## ASSESSMENT REPORT

### Building R1, Barangaroo South SSD 6513 MOD 3

This report provides an assessment of a section 96(1A) modification application lodged by Lend Lease (Millers Point) Pty Ltd (the Applicant) seeking to modify a State significant development application (SSD 6513) for the construction and use of Building R1 as a pub at Barangaroo South within the City of Sydney local government area. The application seeks approval for design amendments to the ground floor planter boxes, four signage zones and minor ground floor design and layout amendments.

RIBBON WALL

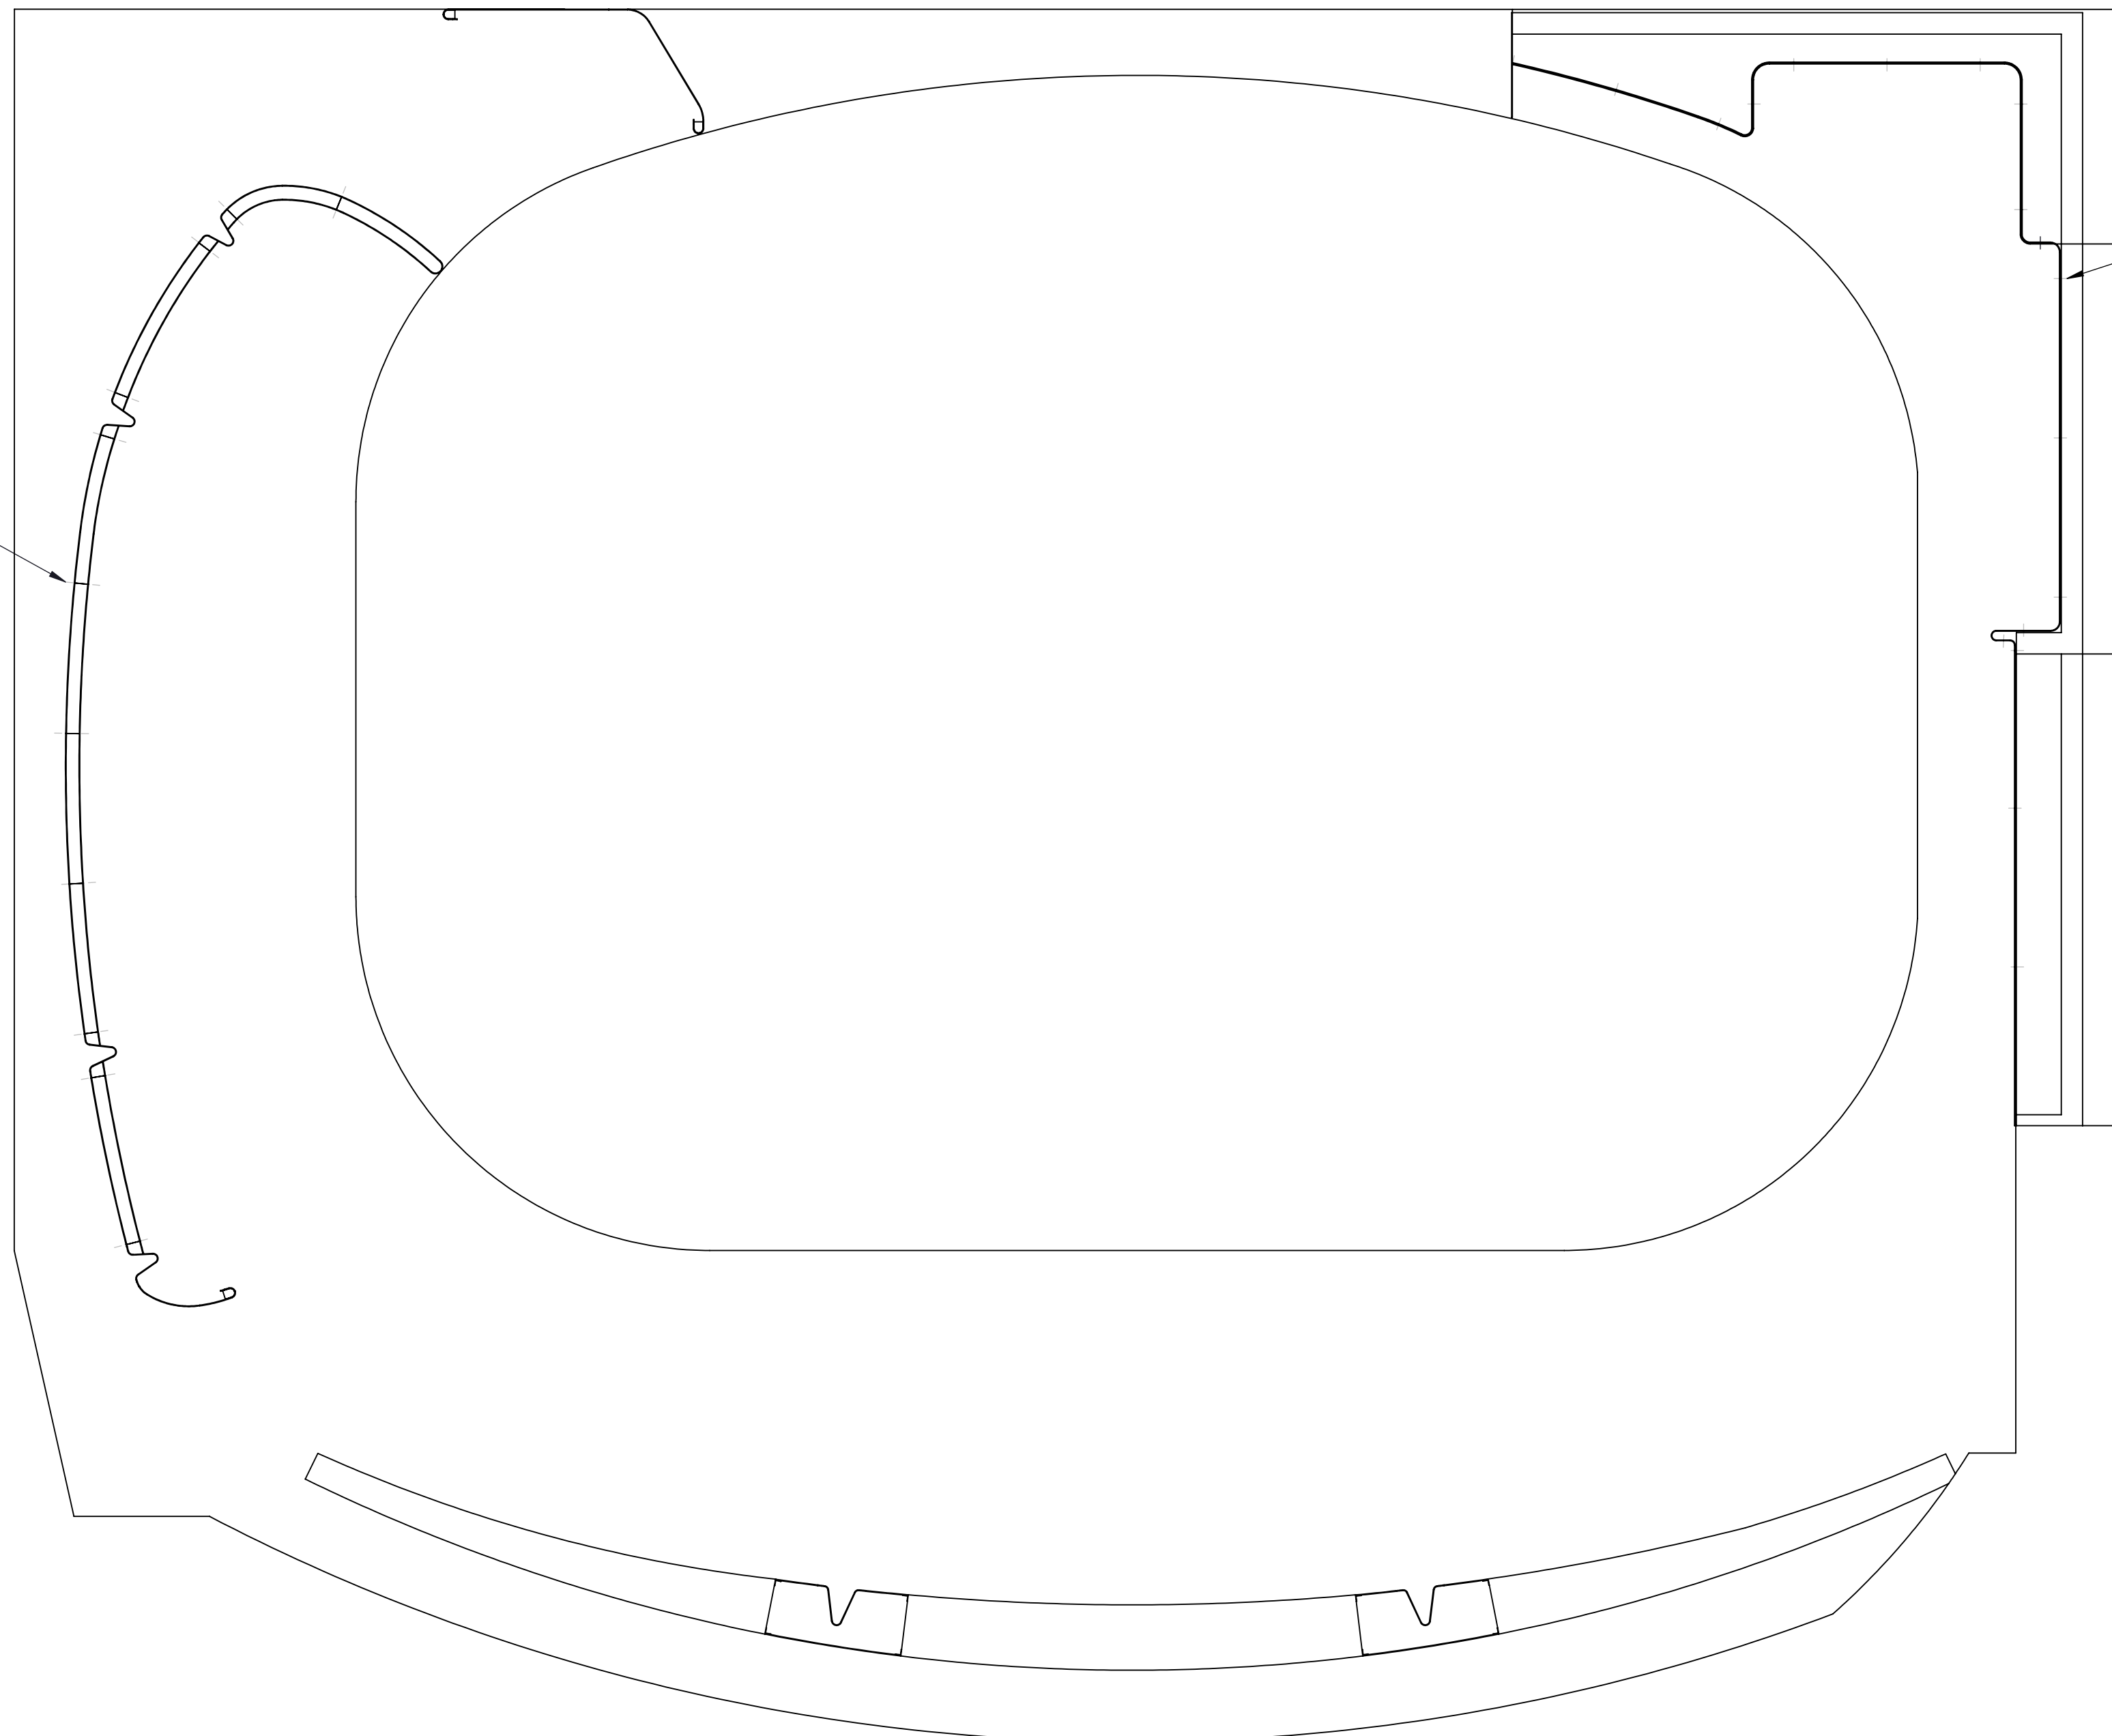
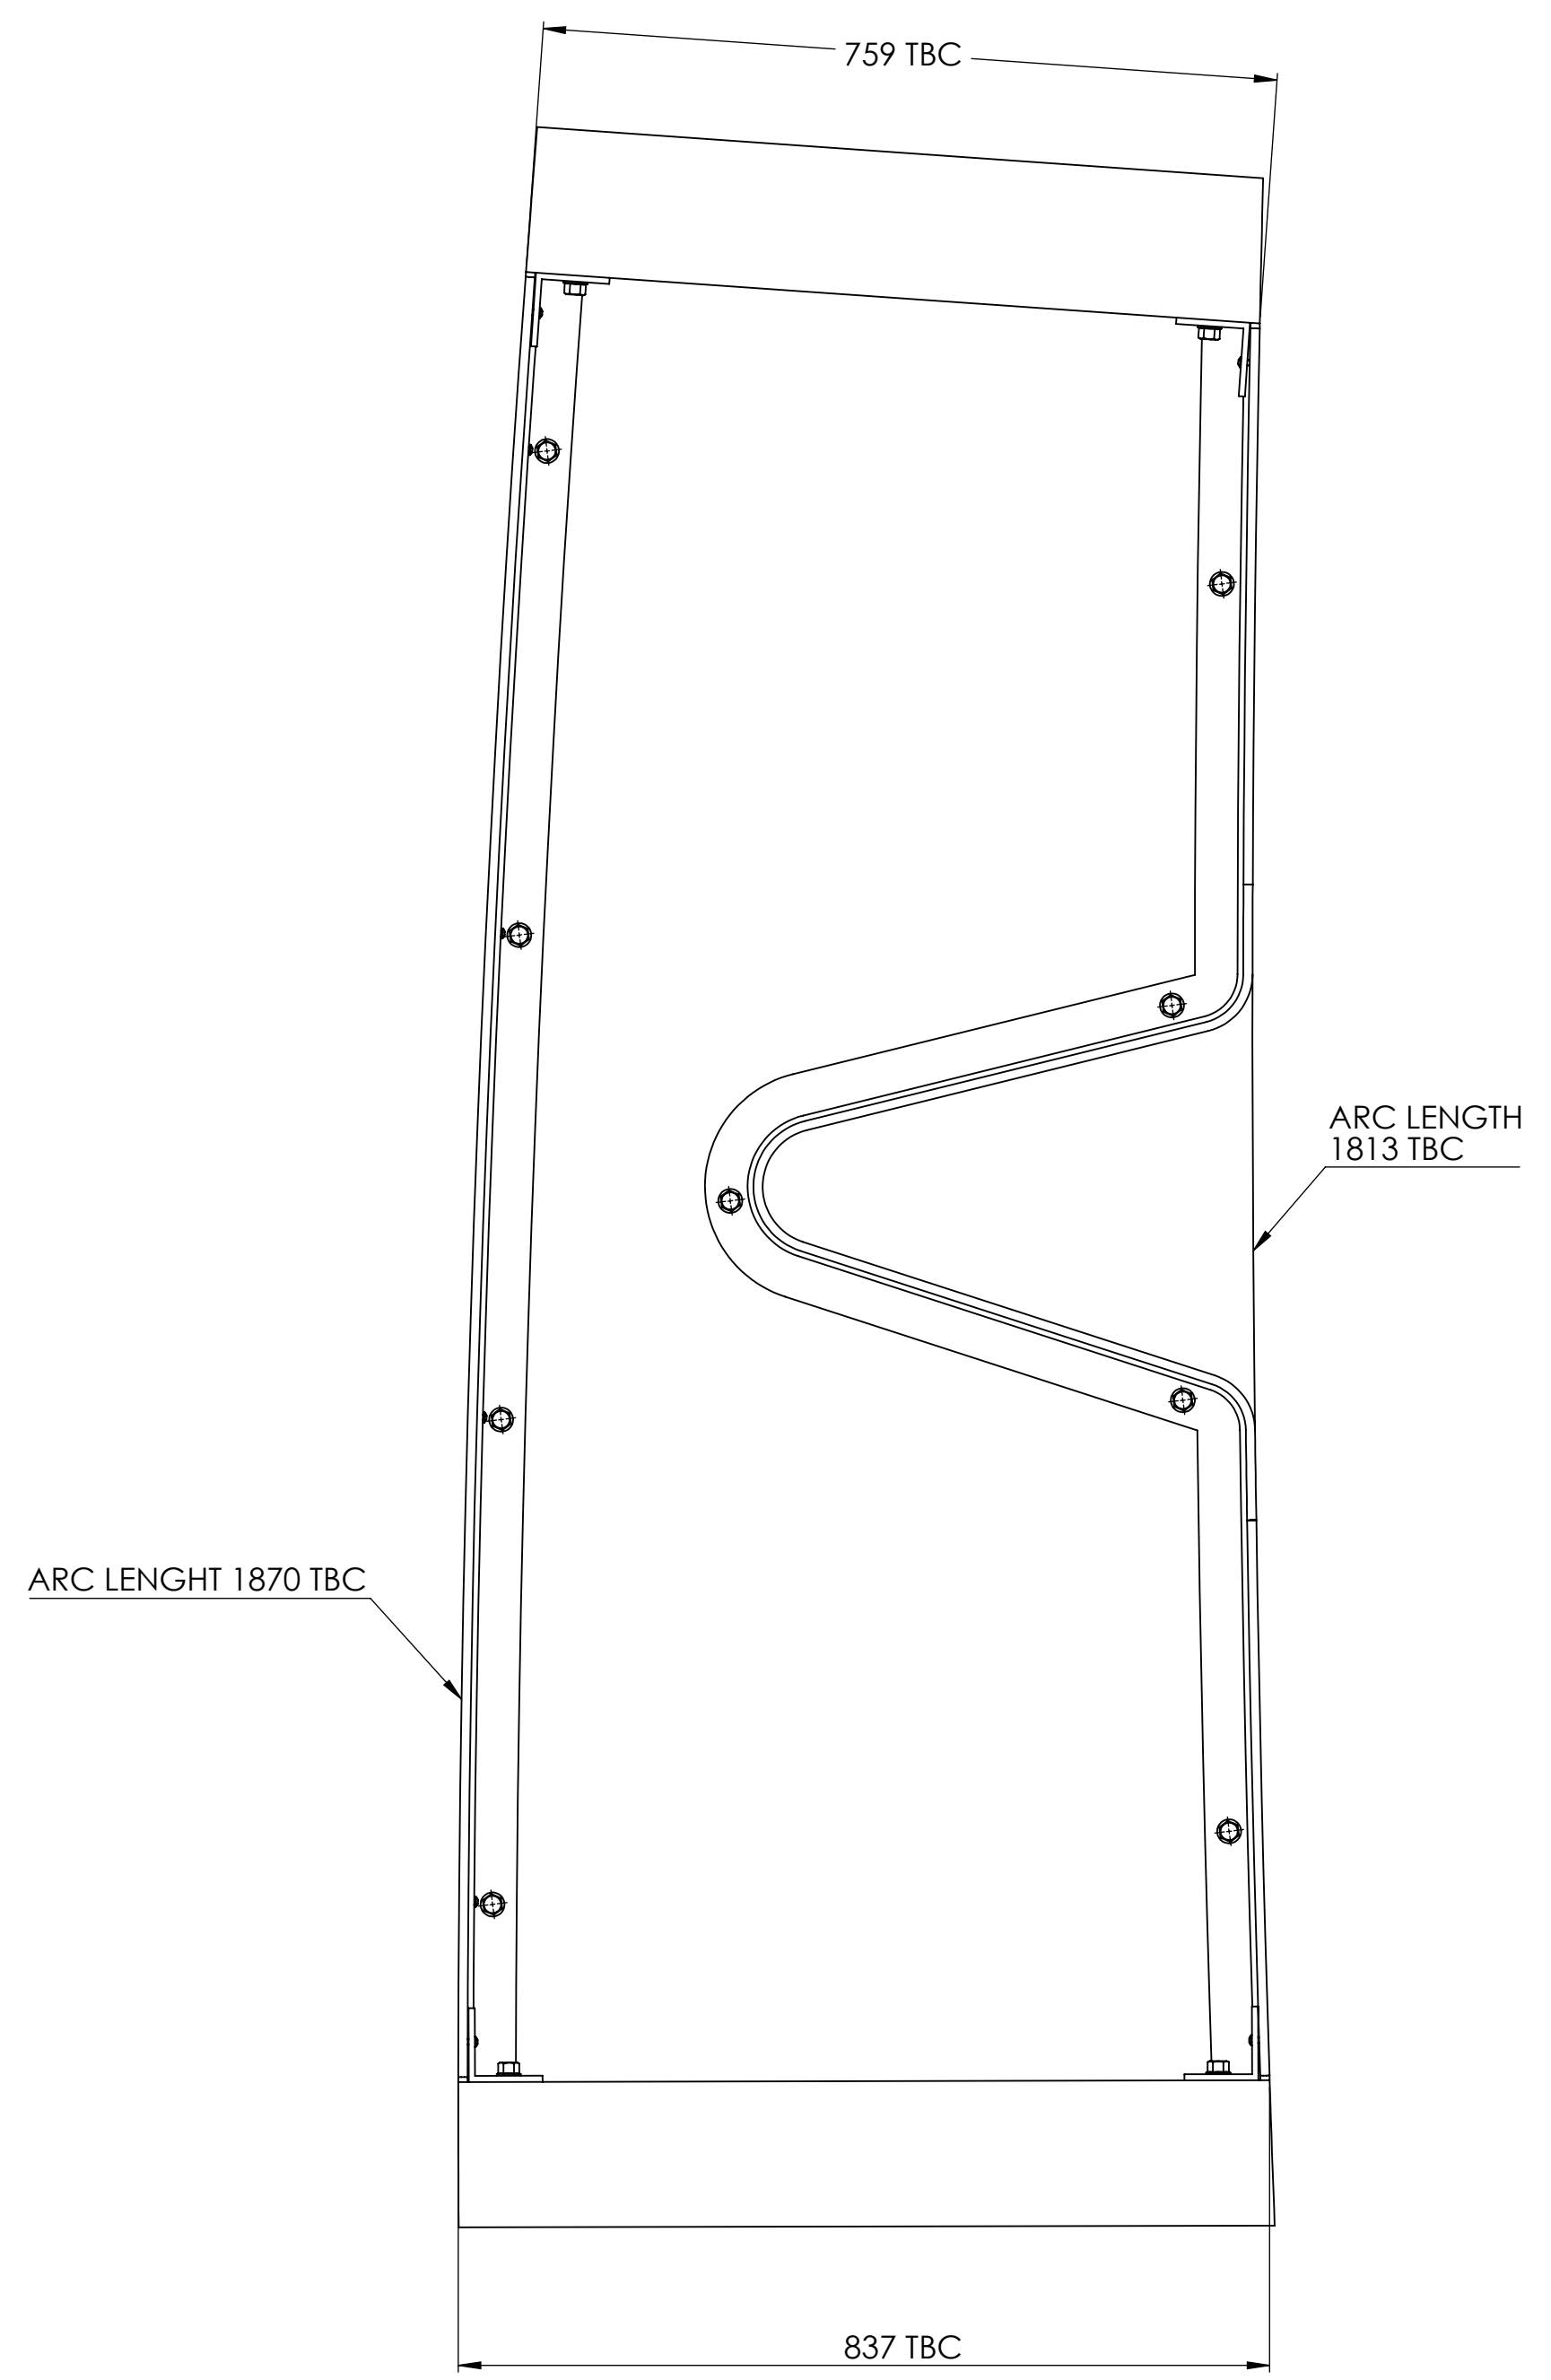
- the need for more detailed plans showing the folded metal planter boxes and how the proposed signage zones integrate with structures
- inadequate consideration of Crime Prevention Through Environmental Design (CPTED) principles
- the proposed new seating zone in the south-eastern corner of the building being isolated from other areas of the building which would limit the ability of staff to properly managed patrons within that space.

Council requested more detailed plans be provided showing the folded metal planter boxes.

In response to Council's concerns, the Applicant provided additional diagrams 'for information' which illustrate the proposed folded metal planter boxes in more detail (**Figure 6**).

The Department has reviewed the information provided and notes the proposed planter boxes have been architecturally treated, integrated into the design of the existing landscaping and appropriately sized to ensure they do not interfere with or detract from the adjoining public domain. The landscaping and materiality (steel) of new planter boxes would be consistent with the approved design.

Given the above, the Department supports the design of the modified planter boxes and is satisfied they would not adversely impact on the surrounding public domain.
